From: Holly Duncan
Sent: Thursday, March 28, 2013 9:42 AM
To: Jeff Watson
Subject: RE: BL-13-00004 Winkle

[BL-13-00004 Winkle](#)

~~EXHIBIT~~  
PROPOSED

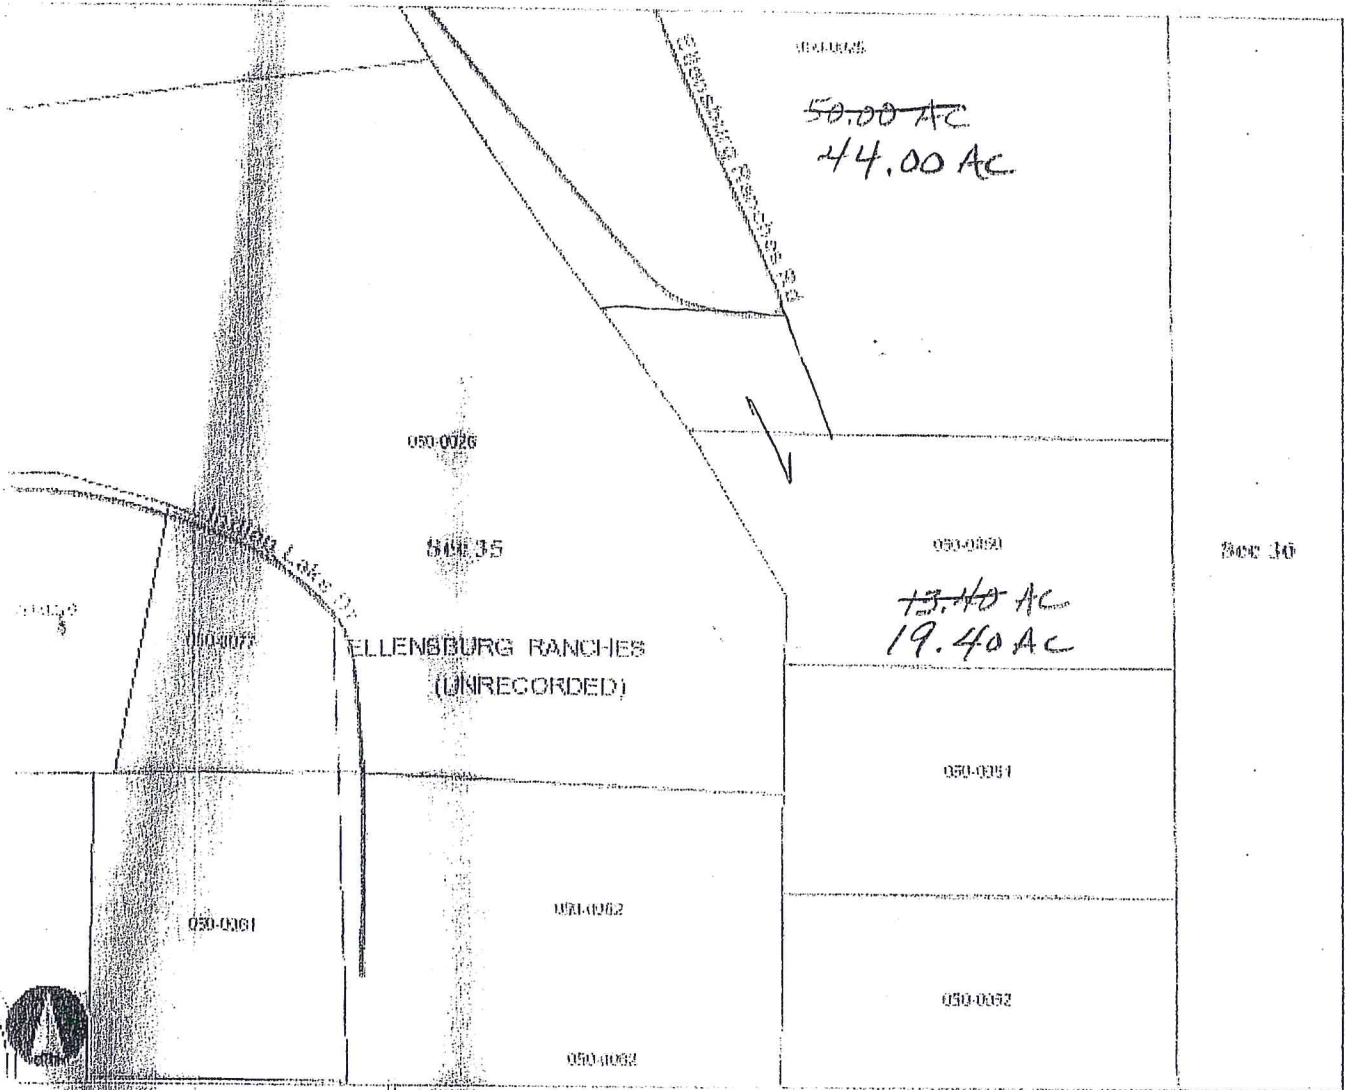
The proposed lot line doesn't look like it will present a problem. I see no well head or any evidence of an on-site sewage system within close proximity. Thank you.
